Jeanie Bourke - RE: Revisions to #2015-02878 Cryptozoology Museum

Thank you for the revised plans. The bathroom fixture count is acceptable for this permit due to the occupant load. With the future tenant C2 fit up, additional fixtures may be required in that space.

I will be approving this permit, please note, it remains in review with the fire department.

**S1.0**

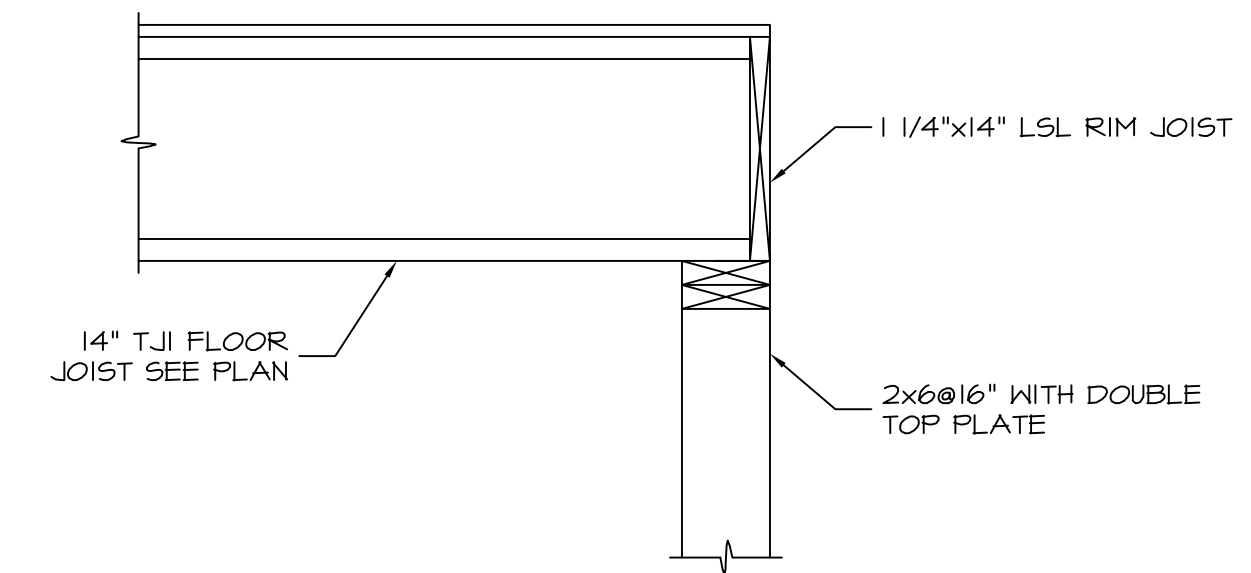
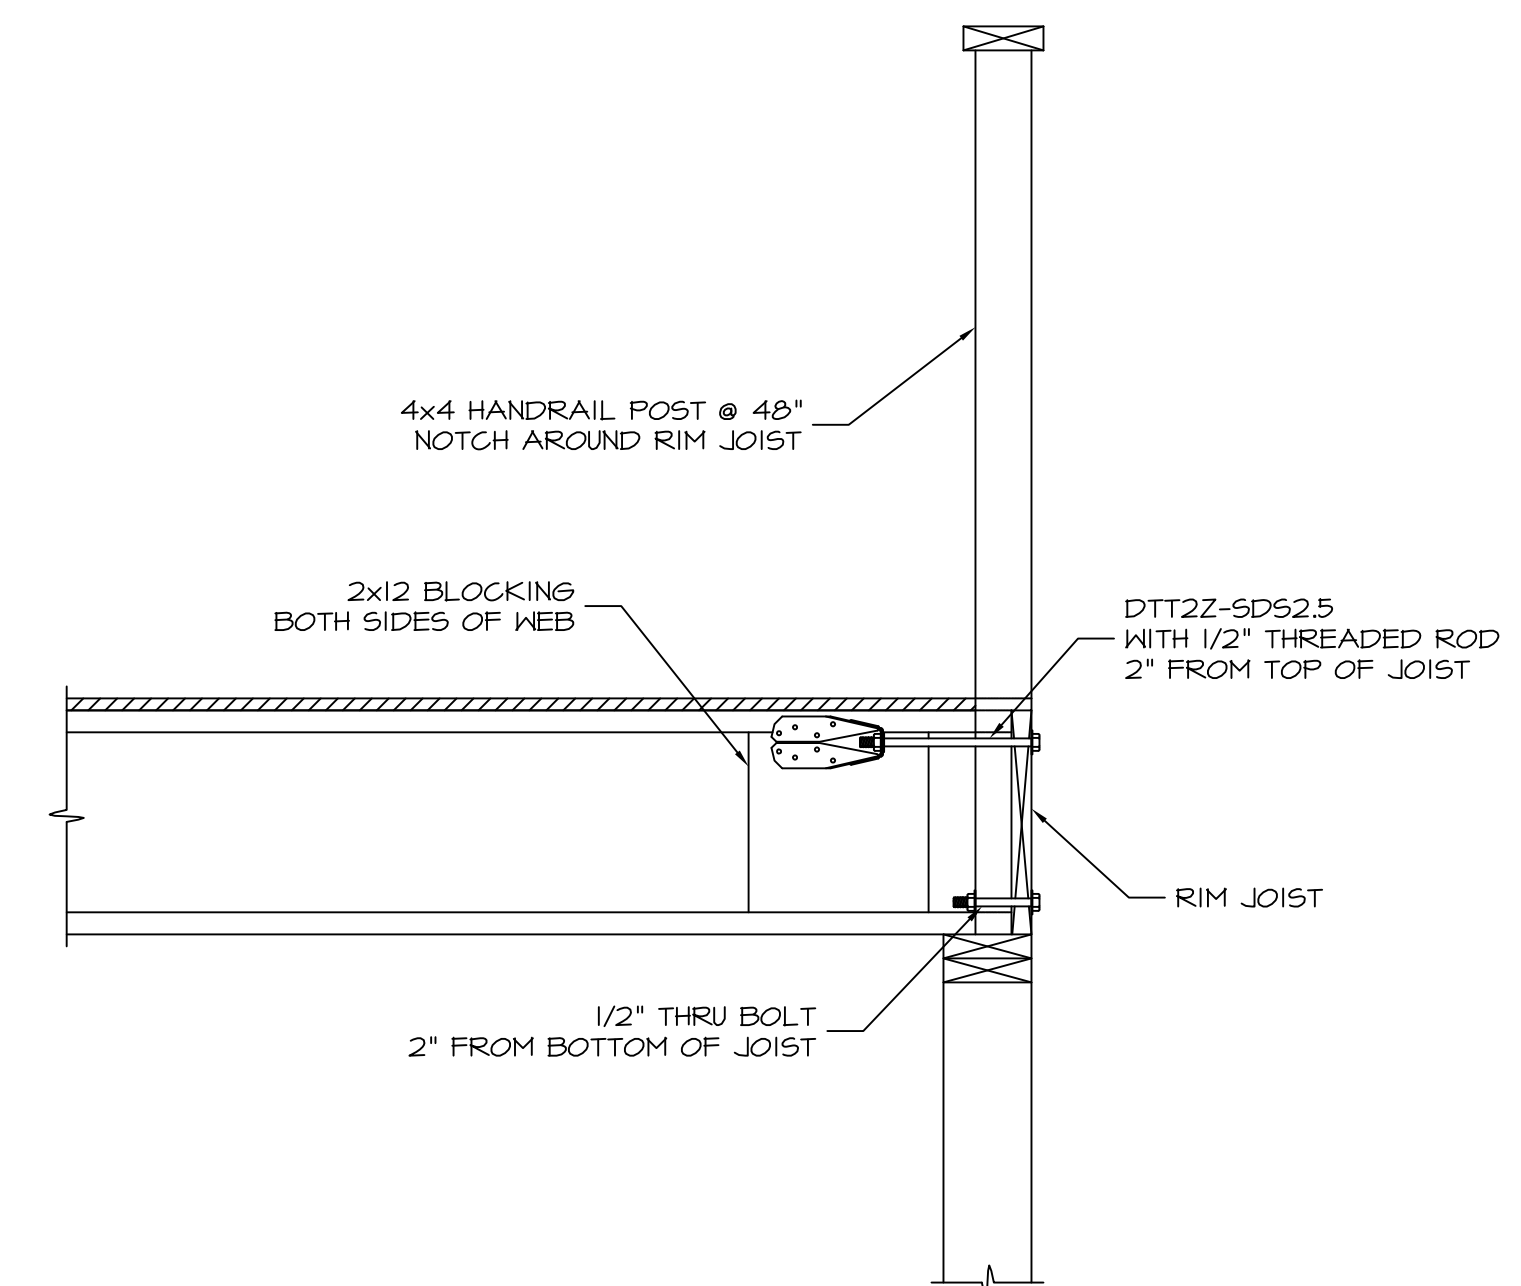
- Added the common room bathrooms to this permit submission and added bathroom elevations with dimensions
- Added fixed seating to the common space and used it to calculate occupancy
- noted designated path for foot traffic, no seating
- added a detail of the thickened slab
- attached the SK of the mezzanine framing section, stamped by my structural engineer
- added a water fountain
- changed the corridor width, it now has a minimum clearance of 44"
- made many small adjustments to walls to get to the 1/3 ratio for the mezzanine space- numbers shown in code analysis
- added a diagram showing the max travel distance from the mezzanine
